From: Ian Hayward [REDACTED] **On Behalf Of** CCD Planning Consultations
Sent: 12 April 2017 15:35
To: Planning.Responses
Cc: Ashvin Patel
Subject: RE: Planning Consultation on AW/20/17/DOC

**WEST SUSSEX COUNTY COUNCIL
STRATEGIC PLANNING CONSULTATION**

SUBJECT: AW/20/17/DOC - Application for approval of matters reserved by condition imposed under AW/141/16/PL relating to conditions 3 - schedule of materials & finishes, 8 - site set up during construction & 10 - tree mitigation

Countisbury Lodge, 7, Countisbury Close, Aldwick, PO21 3QW

DRAWING	BR 014 Method Statement Site Plan		
DATE	10 01 17		
AUTHOR	AH	REVISION	CORINTHIAN ARCHITECTURAL DESIGN 8 Davys Court, Funtington, Chichester, West Sussex. PO18 9LG 01243 576 078 > contact@corinthianad.co.uk > www.corinthianad.co.uk
STATUS	DRAFT BR		
SCALE	1: 200 @ A3

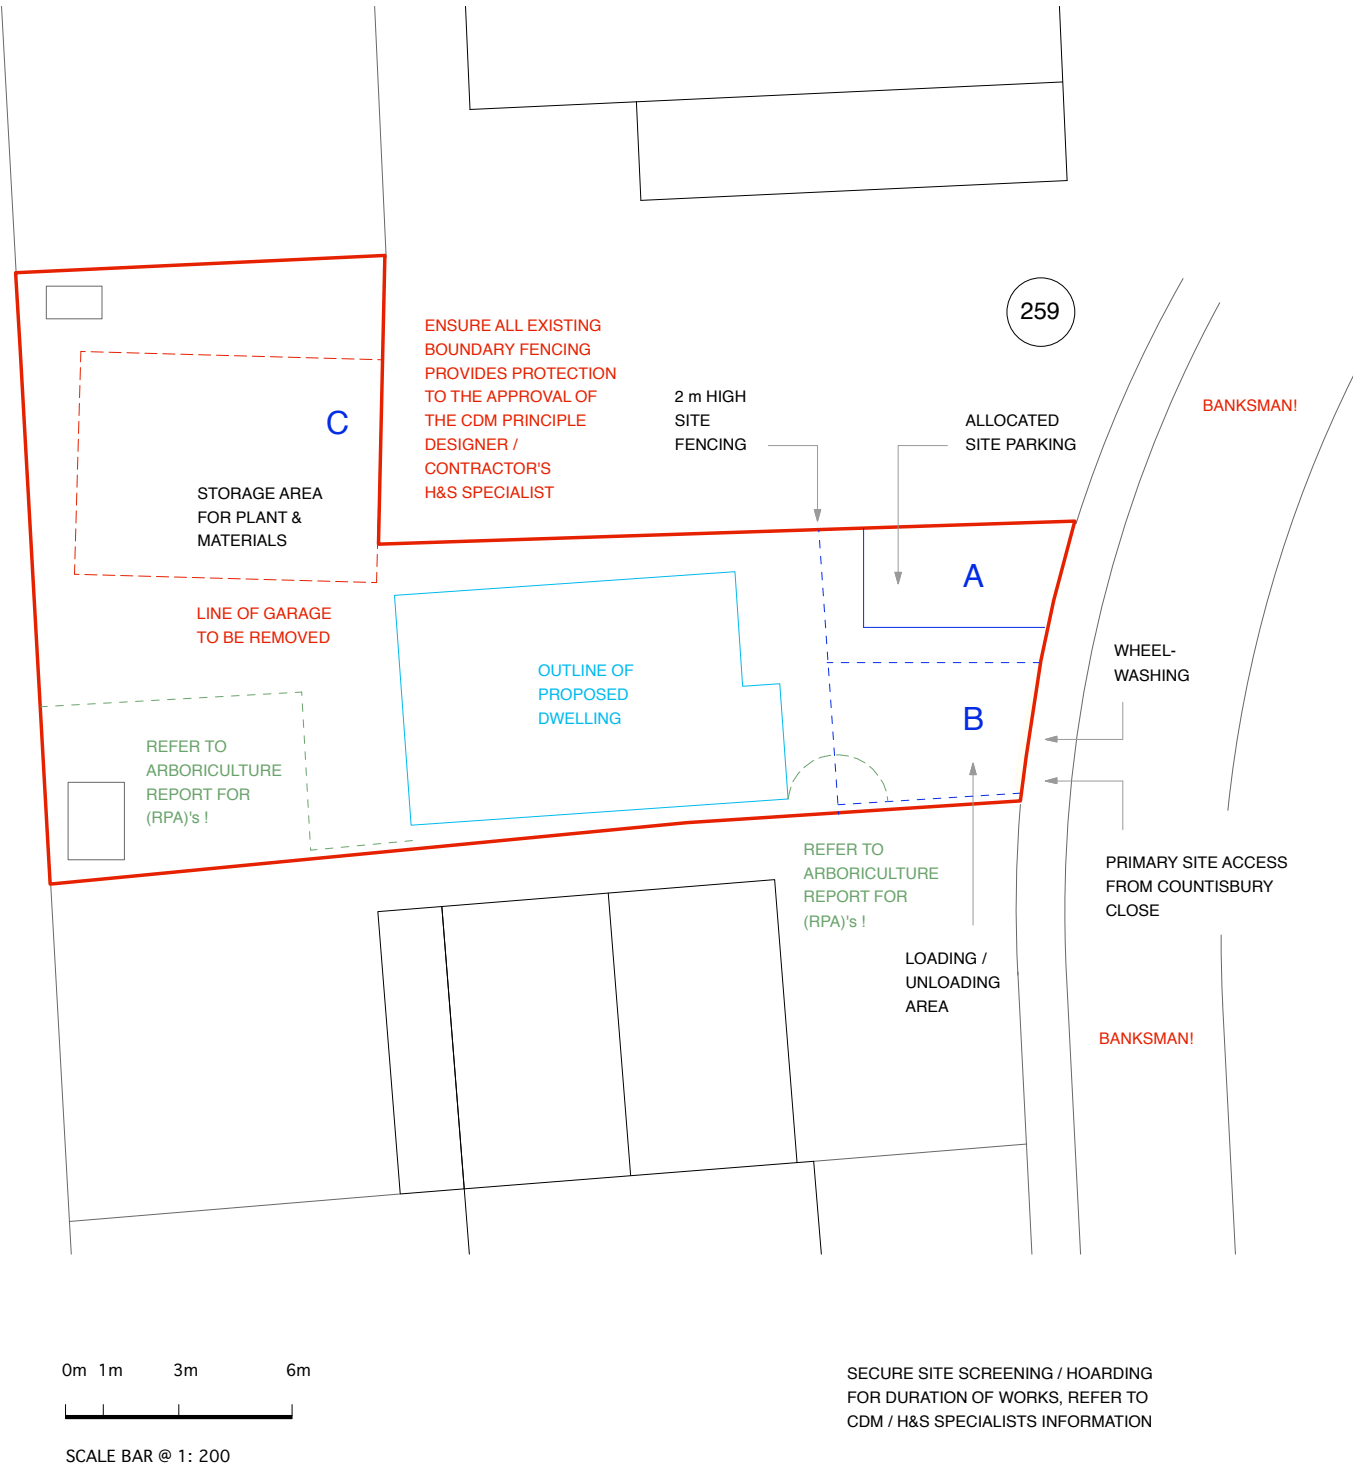
The applicant has provided a construction methods statement detailing the site set up during construction. All storage of plant and material is to be undertaken within the confines of the site. Delivery and construction vehicle movements are to be accompanied by a banksman.

The Local Highways Authority would be satisfied with the plans and details provided pertaining to this condition.
